45-53 Macleay Street Potts Point

Response to Submissions

This Submissions Report has been prepared by Urbis on behalf of Time & Place Pty Ltd (**the Applicant**) to address the matters raised during the public exhibition of the State Significant Development Application (**SSDA**) for the redevelopment of 45-53 Macleay Street, Potts Point (SSD-79316759).

3 ENVELOPE PLAN - LEVEL 3
 1 : 200

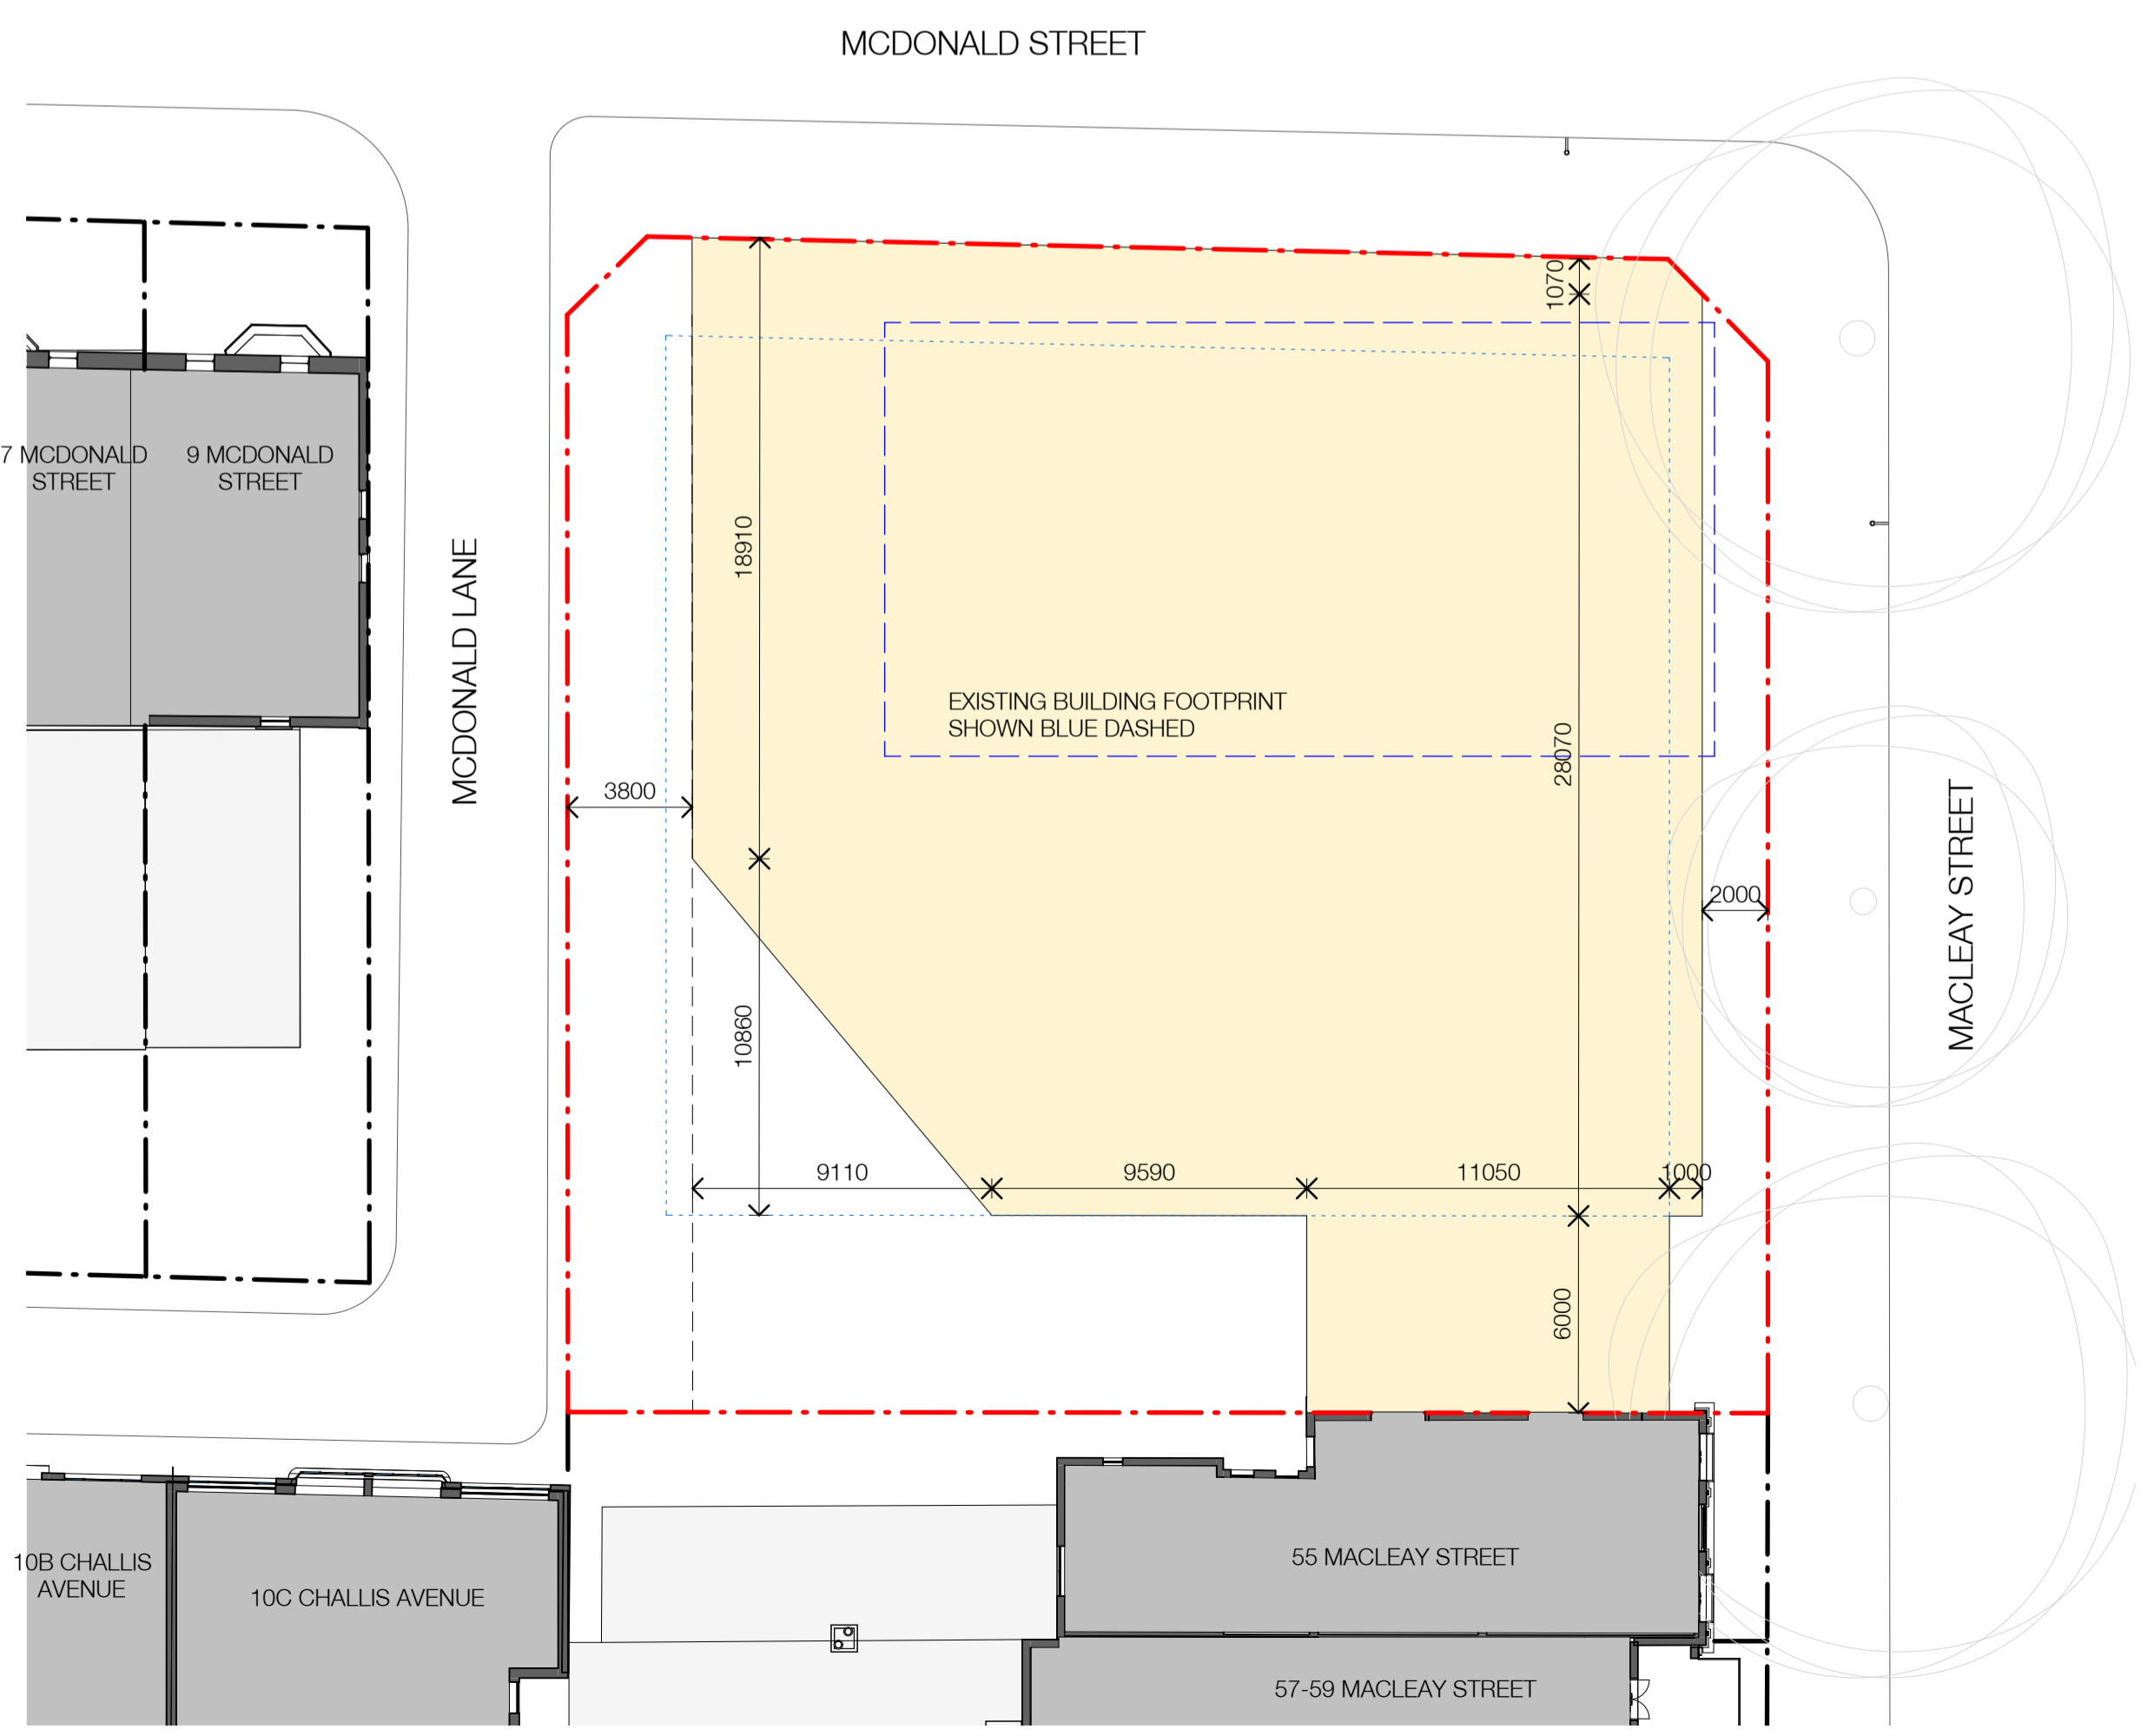
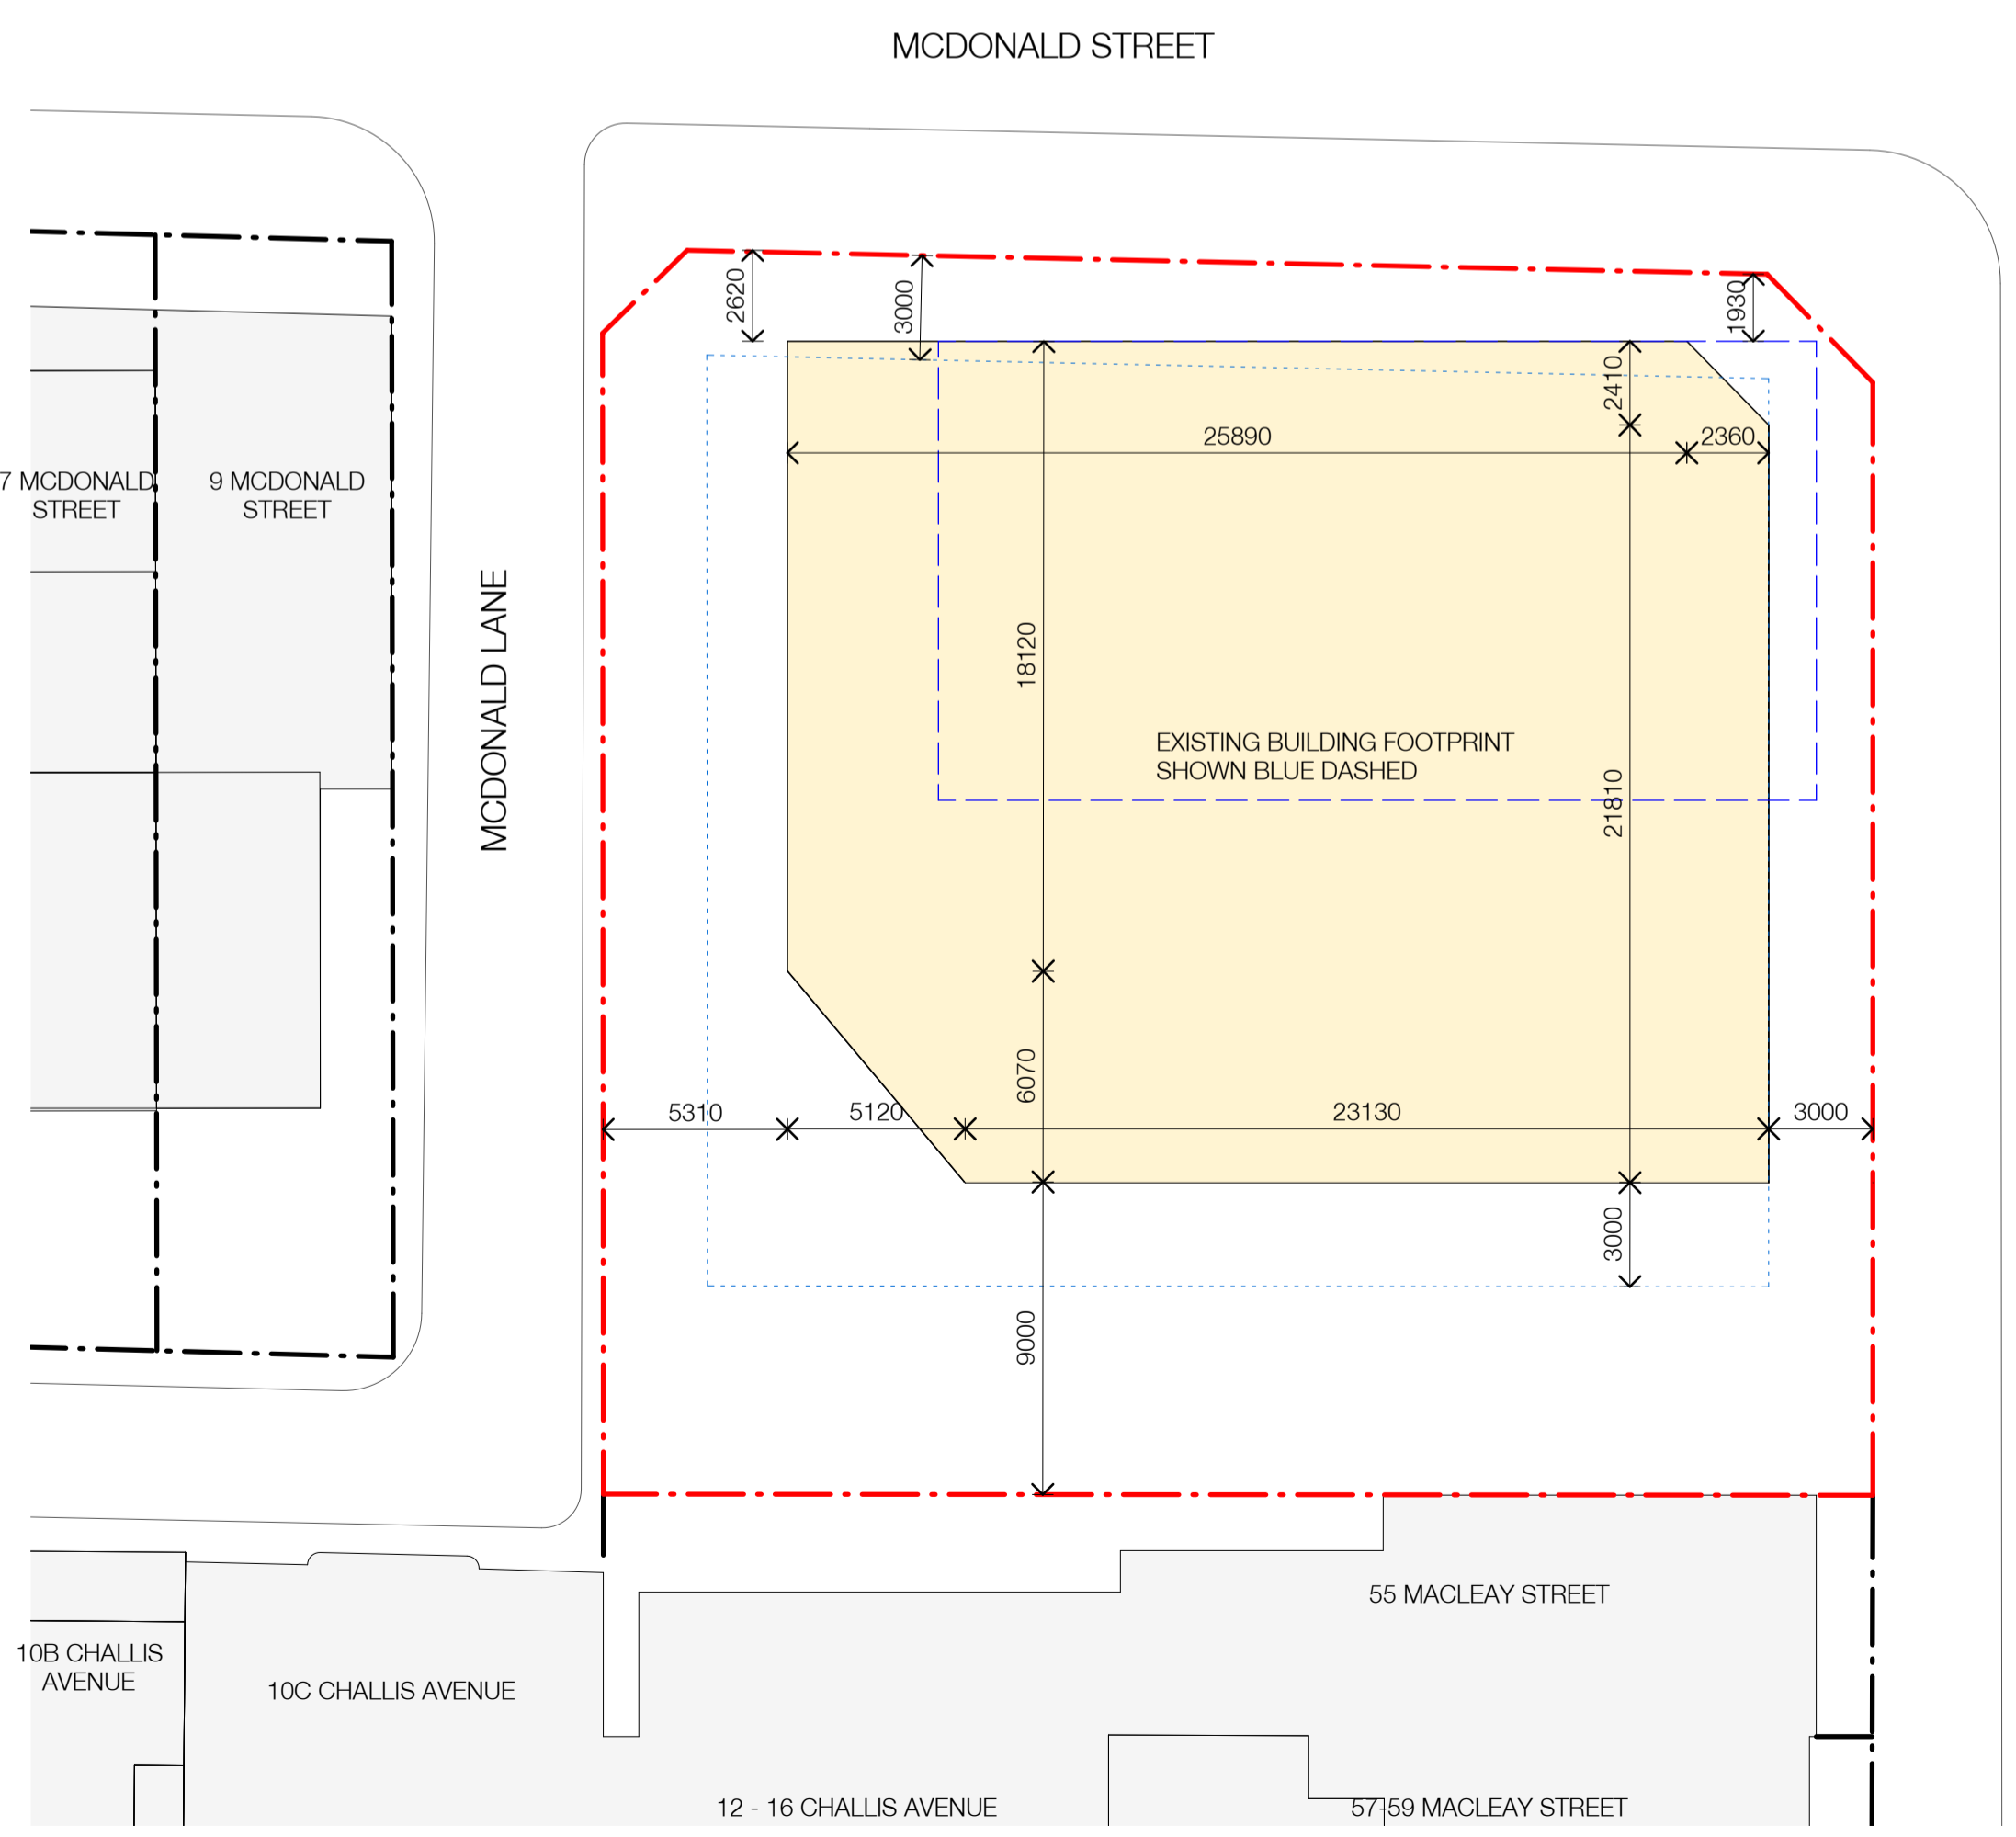
Building setbacks / building envelope		
<ul style="list-style-type: none"> ▪ The proposed building envelope setbacks are unclear and inconsistent. The setbacks dimensioned on the building envelope plans, and as noted in the EIS, do not appear to be measured from the proposed building envelope (depicted in yellow). Detail the setbacks from the proposed building envelope and clarify what the blue dotted line is depicting on the building envelope plans and update the legend accordingly. 	<p>Updated envelope plans have been provided by SJB which include setbacks dimensioned from the proposed building envelope. The plans have been updated to clearly indicate that the blue dotted line depicts the existing building envelope.</p>	Appendix C
<ul style="list-style-type: none"> ▪ Provide an analysis demonstrating that the proposed building setbacks are consistent with the prevailing street pattern in the vicinity of the site. <ul style="list-style-type: none"> ▪ ▪ Address Council's concerns regarding the Macleay Street front setback and the impacts on existing street trees. 	<p>The Envelope Plans (Appendix C) have been revised to provide a 2m setback to Macleay Street from Ground to Level 2 which is largely consistent with the setback of the existing building on the site.</p> <p>From Level 3 to 12, the proposal includes a 3m setback to Macleay Street to maintain the three-storey street wall height which aligns with the prevailing street pattern in the vicinity of the site.</p> <p>The proposal includes a 3.8m setback to McDonald Lane from Ground to Level 2 and 5.3m setback from Levels 3 to 12.</p>	Appendix C Appendix E

<ul style="list-style-type: none"> ▪ The proposed basement setbacks are unclear and inconsistent. The building envelope plans include a notation stating there will be a 2m setback to the basement, whereas the elevation plans show the 'extent of basement' being to the property boundaries. Clarify the extent of basement excavation proposed. The extent of basement is also required to confirm the proportion of deep soil to be provided for the development. 	<p>Updated envelope diagrams have been provided by SJB which confirm that a 2m setback is provided to the basement.</p>	<p>Appendix C</p>
<p>Wind impacts</p>		
<ul style="list-style-type: none"> ▪ Public submissions and Council raised concerns regarding wind impacts. Provide an updated Pedestrian Wind Environment Assessment which details the wind impacts of the proposal on the surrounding locality. 	<p>A Wind Assessment has been prepared by CPP Wind Engineering Consultants (Appendix F) to assess the likely impact of the proposed development on the pedestrian wind environment, with wind activity from north-easterly, southerly and westerly winds assessed. The analysis of the wind effects relating to the reference scheme have been carried out in the context of the local wind climate, building morphology and land topography.</p>	<p>Appendix F</p>

Issue Raised	Response	RTS Reference
<ul style="list-style-type: none"> Deep Soil area should be clearly identified on the envelope drawings, including an annotation to identify the minimum quantum. 	<p>The Updated Envelope Drawings (Appendix C) demonstrate a 3.8m setback from the basement and ground floor levels to McDonald Lane to facilitate deep soil planting. The deep soil planting area is indicated in the Landscape Report provided at Appendix P to the EIS. The final details of the deep soil provision on the site would be confirmed as part of a future detailed application.</p>	<p>Appendix C</p>
<ul style="list-style-type: none"> Setbacks are not adequately dimensioned on the envelope drawings – the envelope should be readily replicable to inform the subsequent design stages. 	<p>Updated Envelope Drawings have been provided by SJB (Appendix C) which clearly dimension the proposed setbacks.</p>	<p>Appendix C</p>
